**KIRKLEES METROPOLITAN COUNCIL
INVESTMENT & REGENERATION SERVICE**

DELEGATED DECISION TO DETERMINE PLANNING APPLICATIONS

Reference No:	2021/62/94201/E
Site Address:	53, Whitley Road, Thornhill, Dewsbury, WF12 0LP
Description:	Erection of conservatory extension with alterations to existing elevation and extension of external patio area including reconstruction of existing retaining wall and incorporation of external store
Recommending Officer:	Elenya Jackson

DECISION – Conditional Full Permission

Rev	Description	Date
<b>MOArchitecture</b>		
Client H Thomson		
Project Conservatory & Patio Extension The Strynes, Thornhill Edge		
Drawing As Proposed		
Project no.	MOA 2111	Scale 1:100/250
Drawing no.	[10] 02	Size A1
		Revision FA
		Status FA

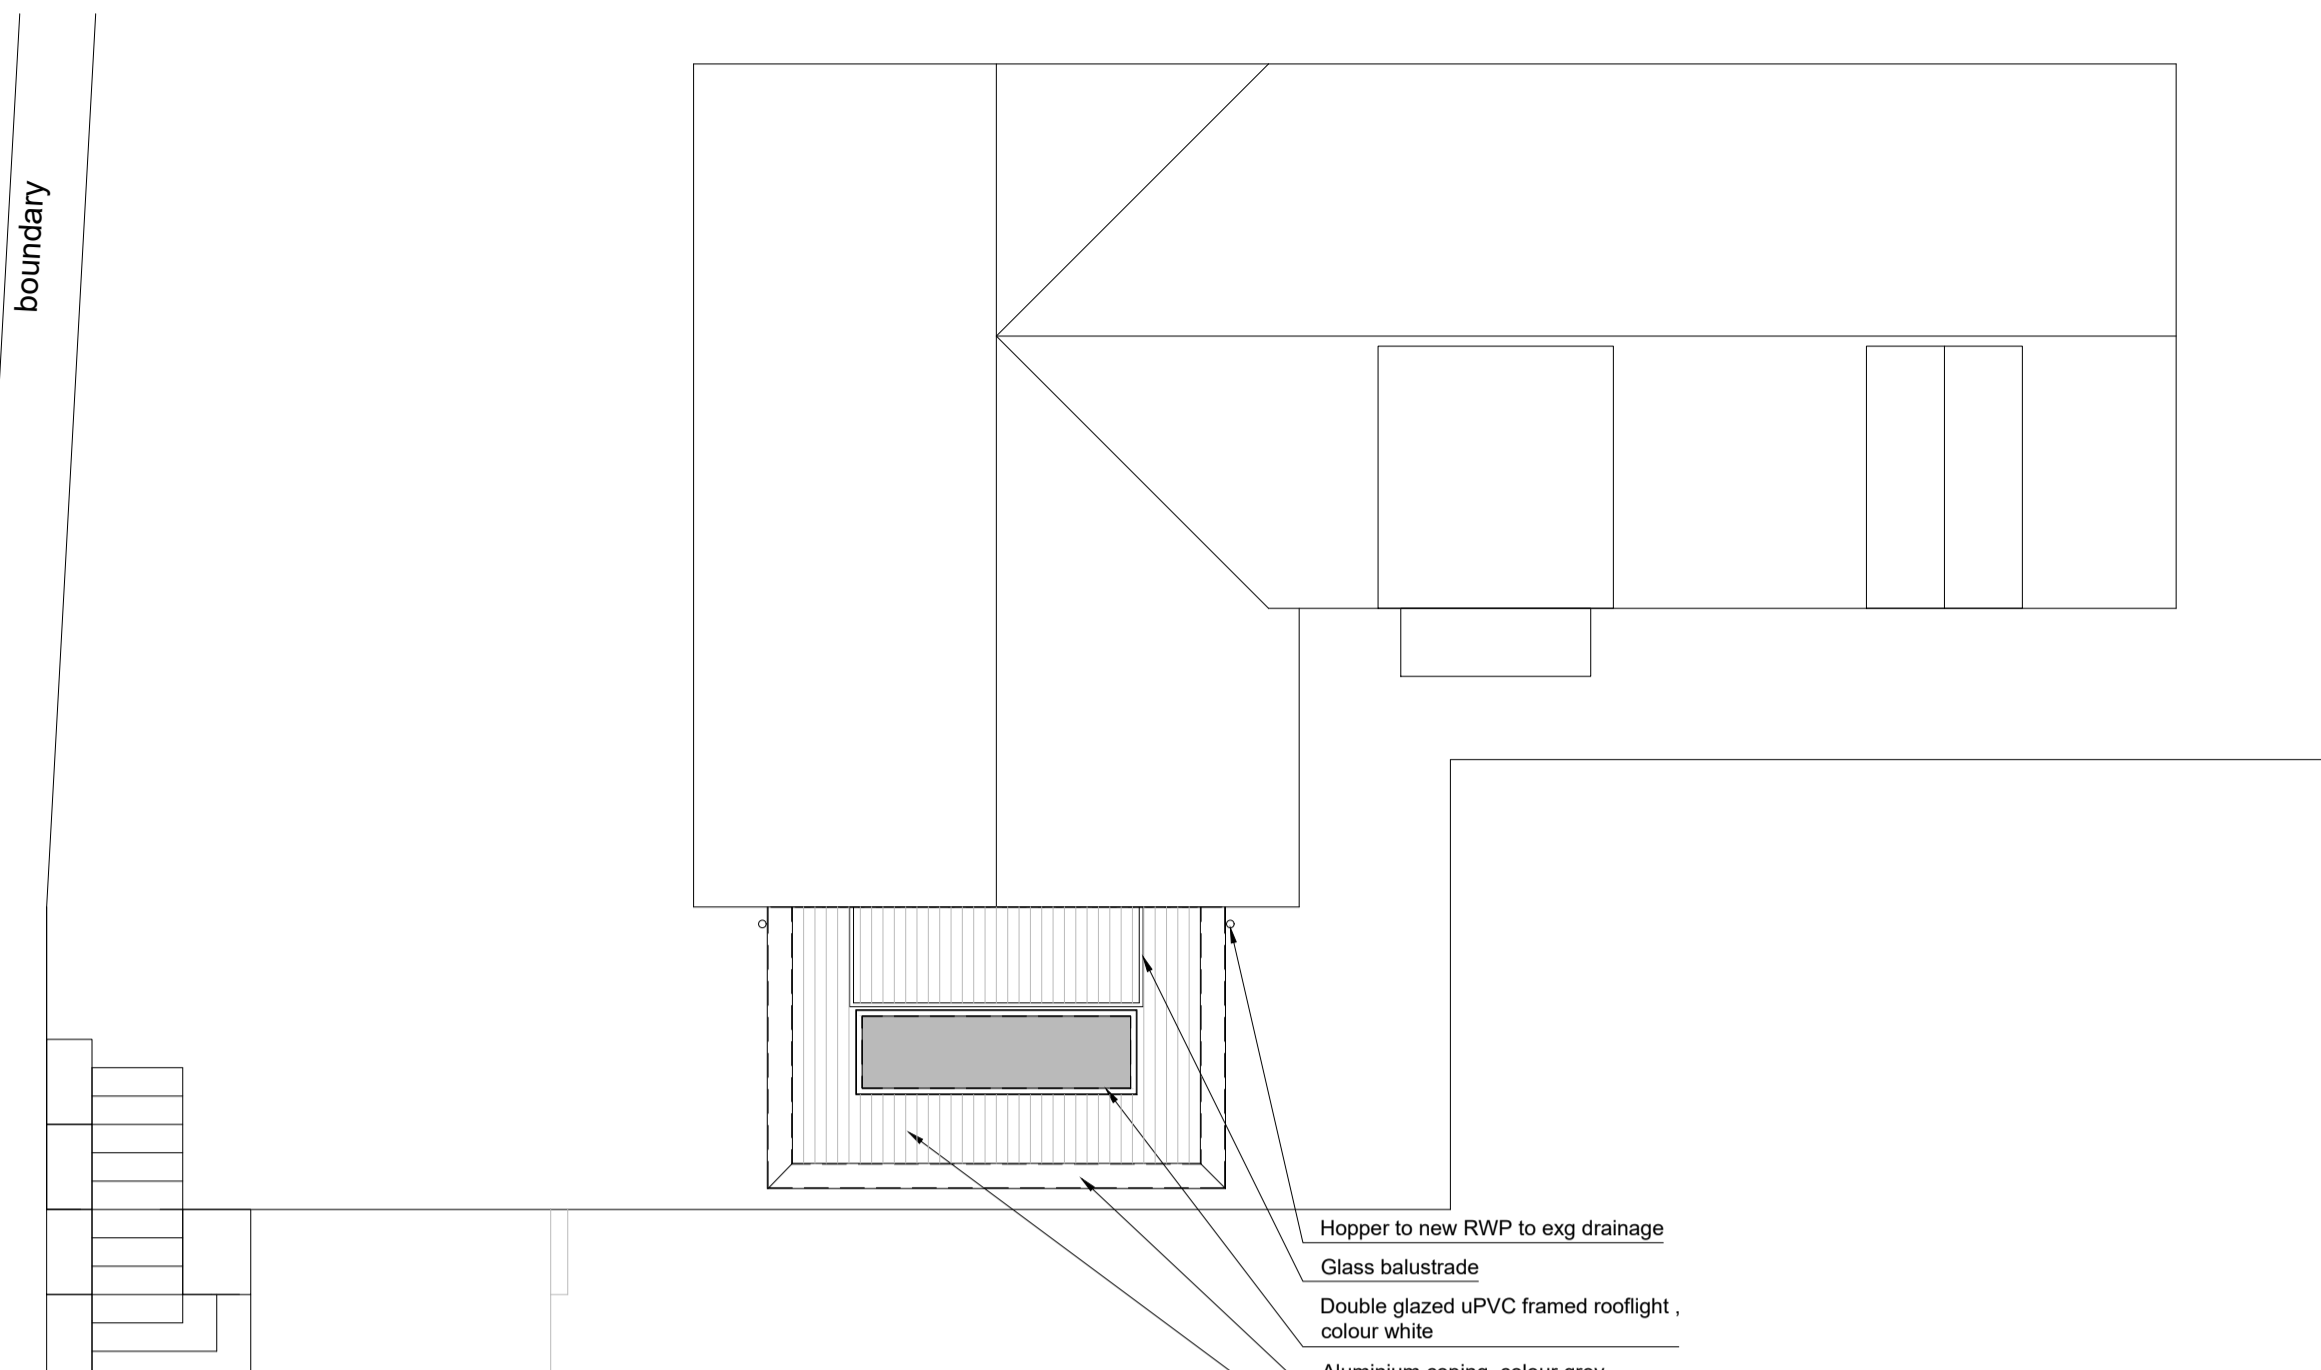
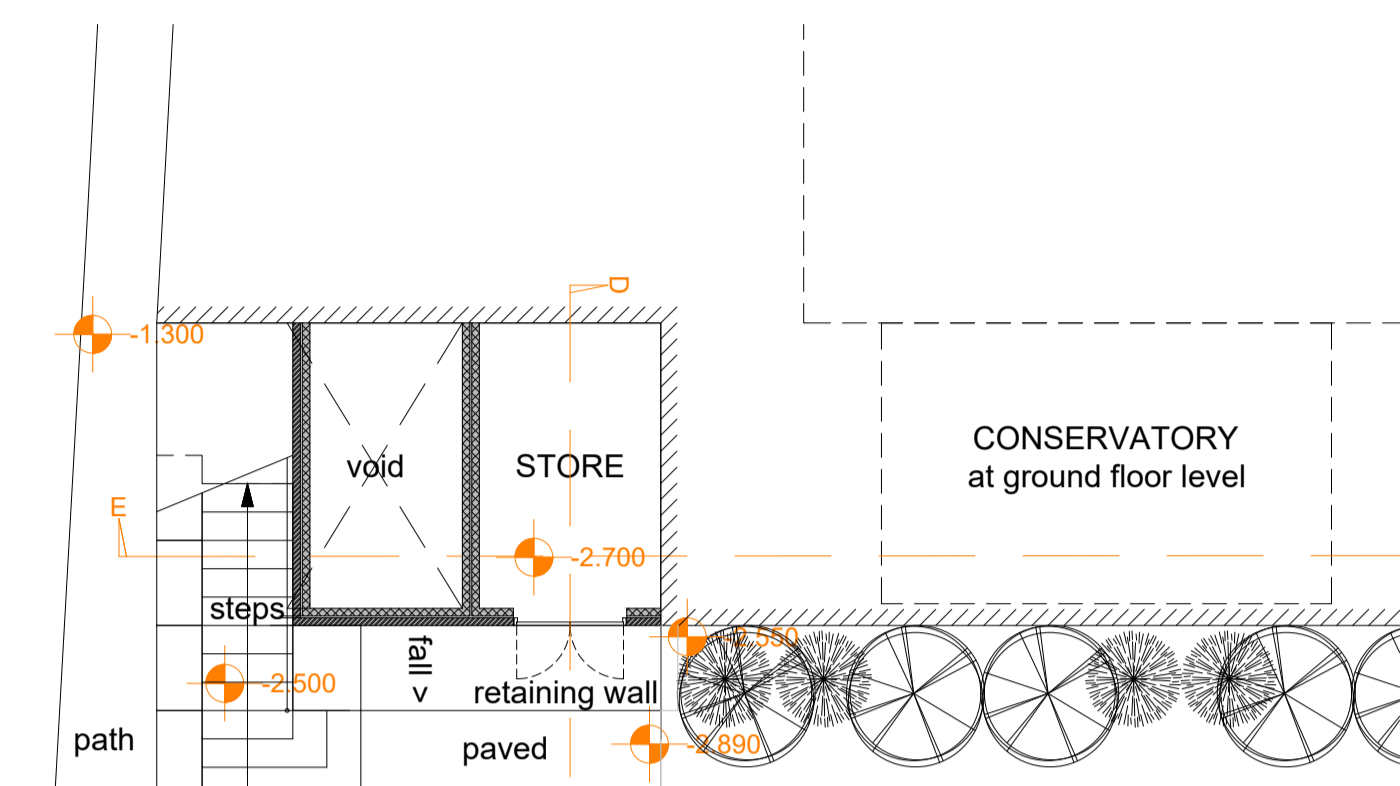
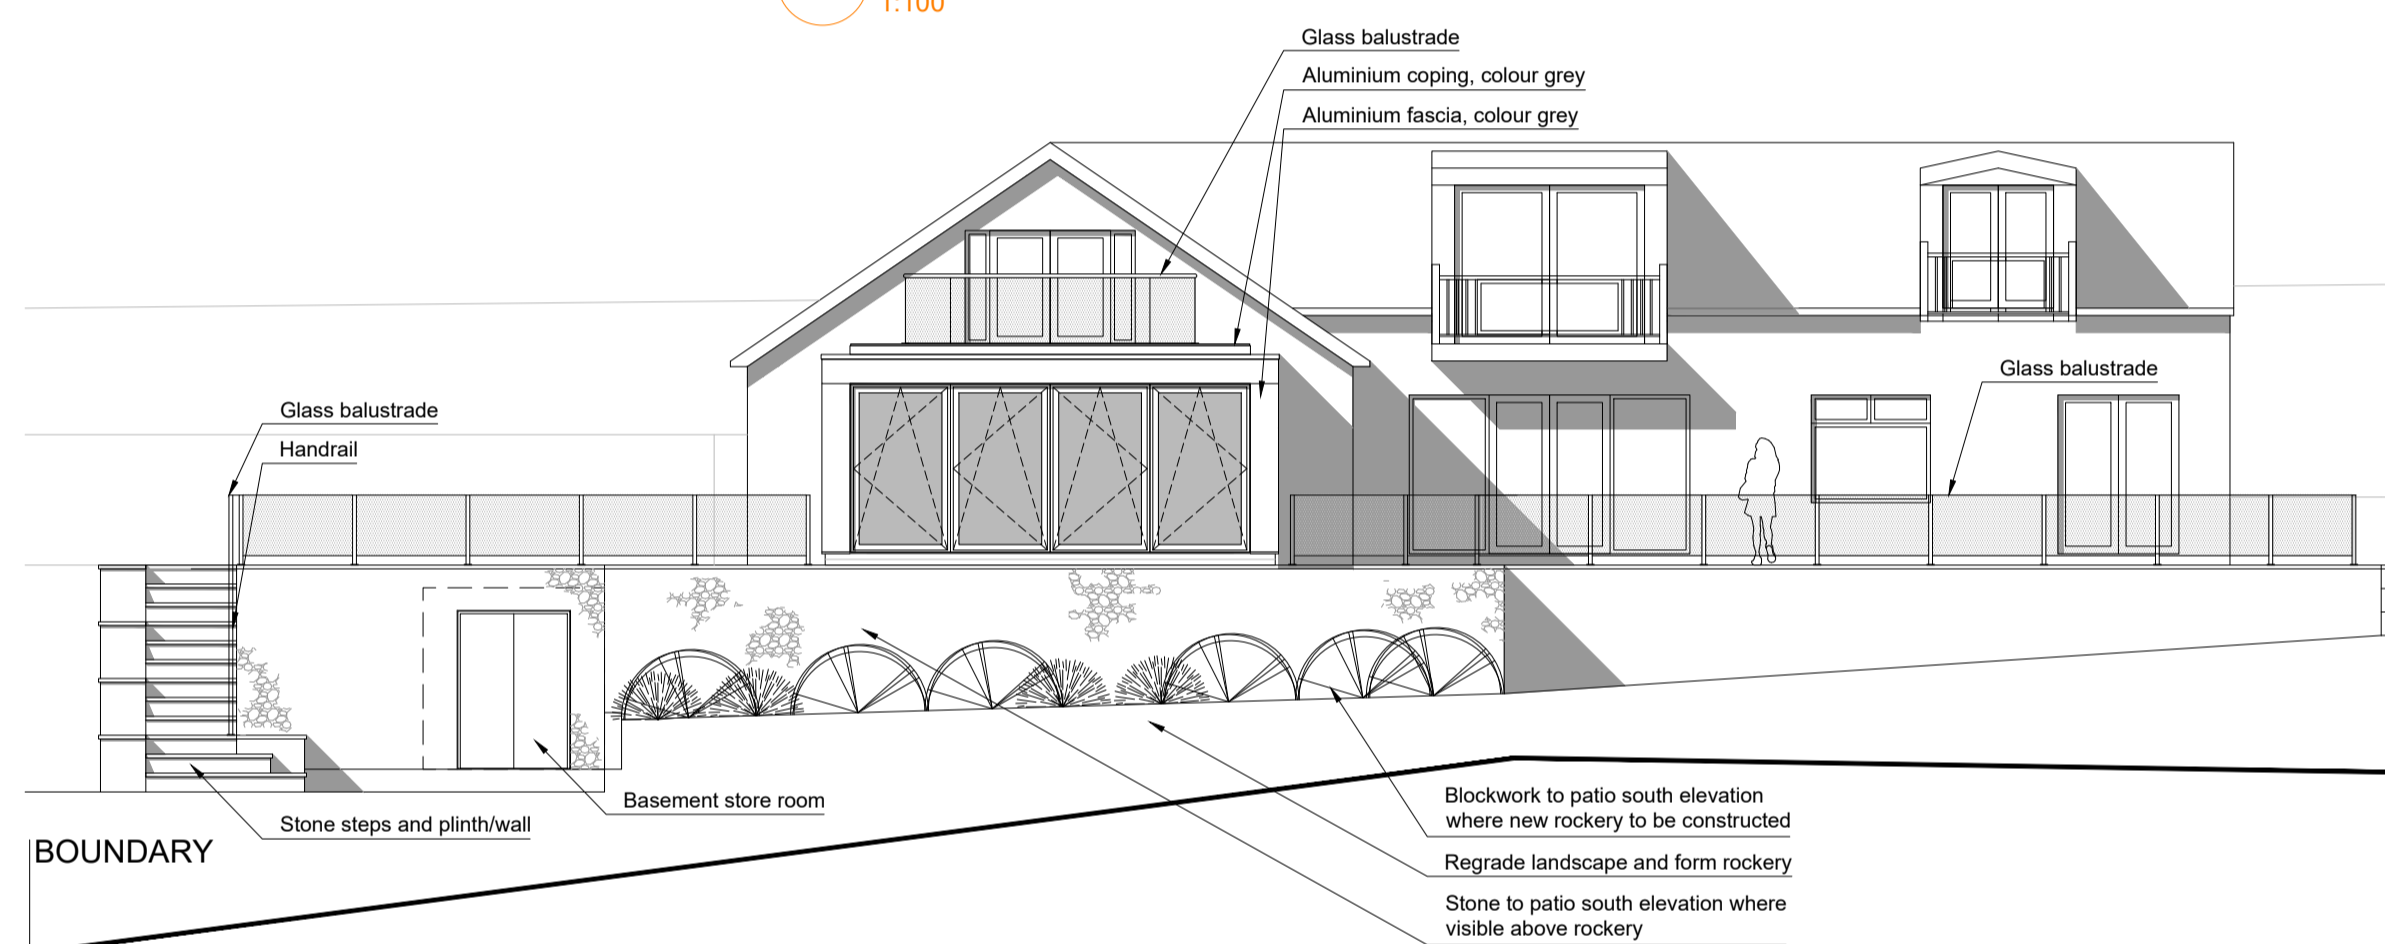
Overlooking: The proposal would be situated 10m away from the shared boundary between the two dwellings and features side facing fenestration. It is considered that a condition requiring a screen to the western elevation of the balcony would sufficiently mitigate any overlooking relationship and this has been agreed with the agent.

4. Notwithstanding the details submitted, prior to the construction of the first floor balcony hereby approved, details of a 1.8 meter privacy screen to be erected along the western elevation of the balcony shall be submitted to and agreed in writing by the Local Planning Authority. Details shall include materials and extent of screening. The privacy screen(s) shall be installed and retained thereafter for the lifetime of the development
